## Appeal Decision

**Appeal Ref: APP/R5510/D/24/3348589**

**57 Thornhill Road, Ickenham, Hillingdon UB10 8SQ**

- The appeal is made under section 78 of the Town and Country Planning Act 1990 (as amended) against a refusal to grant planning permission.
- The appeal is made by Dr Adnan Bashier against the decision of the Council of the London Borough of Hillingdon.
- The application Ref is 33915/APP/2024/1063.
- The proposed development is the installation of eight air conditioning units.

SIDE ELEVATION

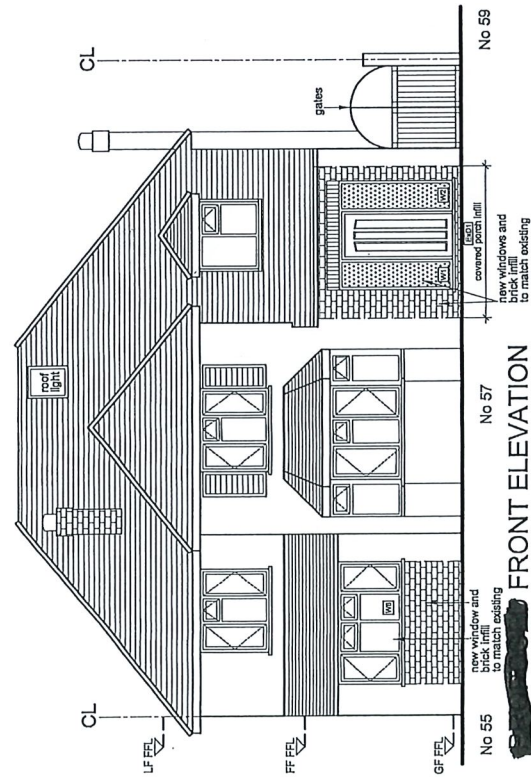
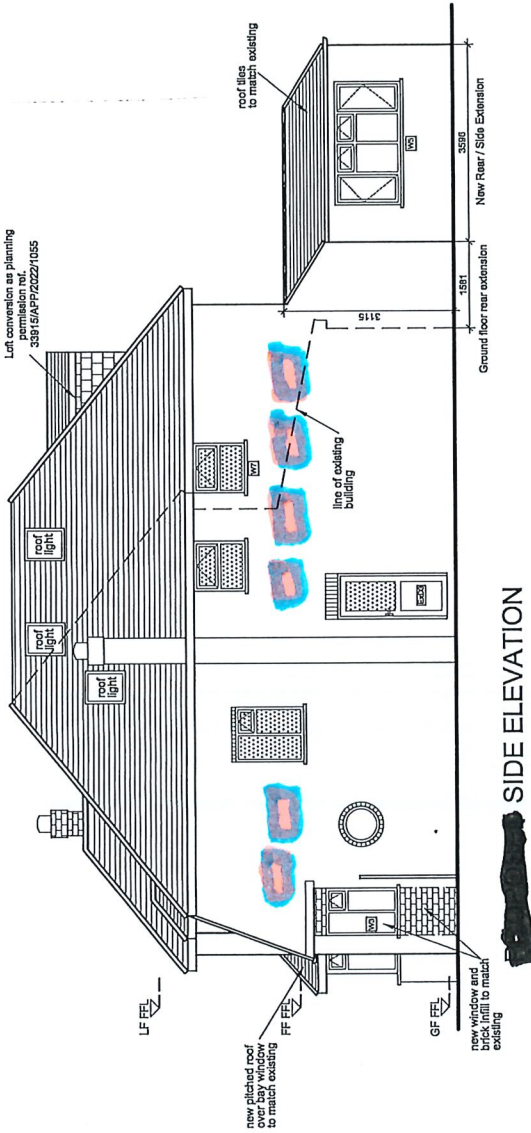
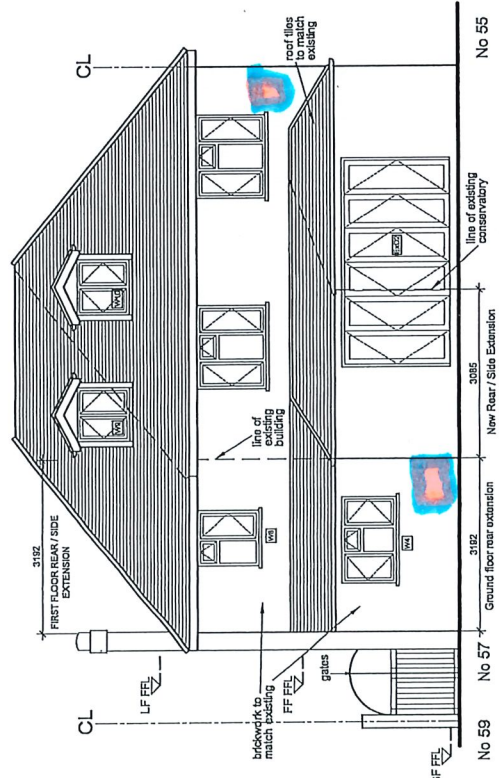
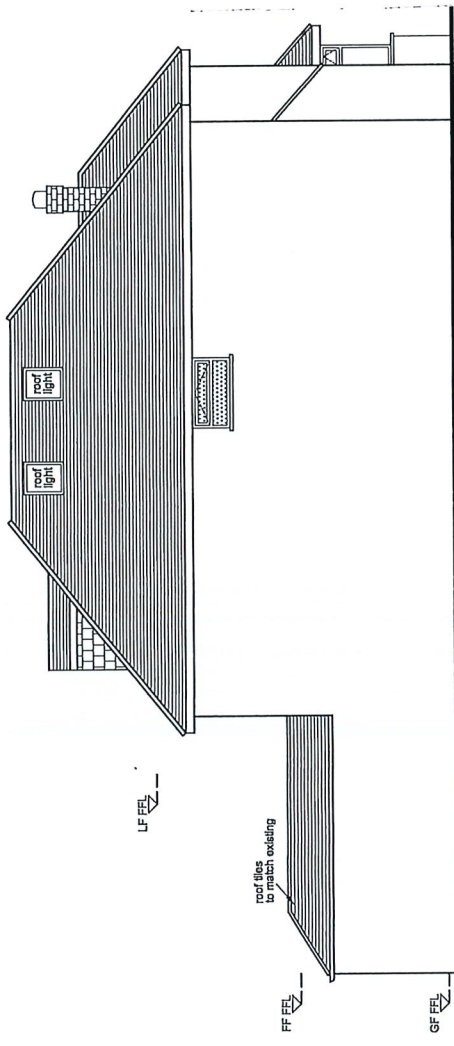
5. The proposed development includes the erection of 8 air conditioning units with 2 located to the rear of the property and 6 erected at first floor level on the property's side elevation. The council's concern is directed primarily at the units erected on the side elevation which comprise 2 units sited close to the property's front elevation with the other 4 units towards the rear of the property. The size of the side elevation is extensive and the erected air conditioning units do not physically or visually dominate this flank wall.

6. There is a gap between the side elevation of the property and the flank wall of 59 Thornhill Road. This gap is between 3 and 4 metres in width. When walking southwards along the footways of Thornhill Road, the erected air conditioning units are not visible until walking past the property. At this point, it is only the 2 units erected closer to the property's front elevation which are visible albeit for a brief time.

7. Walking northwards, because of their siting and the proximity of No. 59, it is primarily the existing 2 units sited closer to the front elevation which are visible from the footway along the west side of the road for about 35 metres. The other 4 units erected on the property's side elevation are only visible for around 15 metres. By reason of siting, the erected units are not so prominent nor conspicuous that they materially detract from the spacious and verdant character and appearance of the streetscene.

12. However, the siting and bulk of the proposed recommended mitigation could significantly increase the prominence of the 2 units sited on the flank wall of the property closest to its front elevation. This potential increase in visual and physical prominence would significantly detract from the character and appearance of the host property and the streetscene, including the positive contribution made by the property's front elevation to the streetscene. The already identified modest harm associated with the recommended mitigation for the other 4 units would accentuate this unacceptable harm. For these

reasons, the appeal scheme would conflict with HLP2 Policy DMHB 12 which requires development to be well integrated with the surrounding area.

Figure 5.5 – Louvre Enclosure – 12dB reduction
Calculations can be seen in Appendix B.

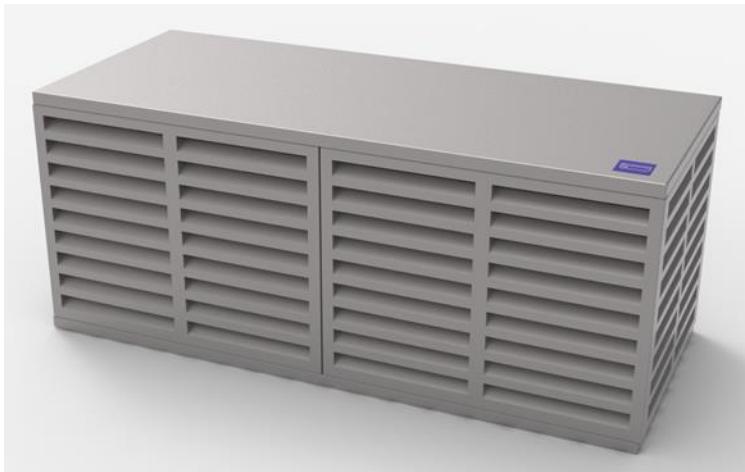
8. However, the appellant's *Noise Impact Assessment* identifies that to comply with guidelines and to achieve the rating levels to avoid harm to the living conditions of the occupiers of the neighbouring property, mitigation is needed for the first floor level rear unit and the units on the side elevation. Concerns about noise levels have been identified by the occupiers of the neighbouring properties and the Council has suggested a condition to secure noise mitigation. No details about the size and siting of the recommended mitigation have been provided on any drawings and reliance is, therefore, placed upon the images included in the *Assessment* which identifies louvre type enclosures.

9. With the recommended mitigation identified, the proposed development at first floor level would project further away from the rear and side walls when compared to the existing situation. At the rear, the addition of the recommended mitigation would not adversely affect the character and appearance of the property. However, the potential size, bulk and elevation above ground level of the proposed mitigation for the 6 air conditioning units erected on the side elevation could cumulatively represent additions which are not subordinate to this flank wall.

10. Although their colour could match the wall's rendering, the bulk and degree of projection of the recommended louvre type enclosures at first floor level could significantly affect the existing character and proportions of the host property which are matters referred to in Policies DMHD 1 and DMHB 11 of the Hillingdon Local Plan Part 2 (HLP2).

11. There would potentially be an increase in the visibility of the 4 units erected on the flank wall towards the rear of the property because of the bulk and size of the recommended mitigation. However, the screening afforded by the proximity of No. 59 means the degree of harm to the character and appearance of the streetscene could be modest and would not alone represent a reason for this appeal failing.
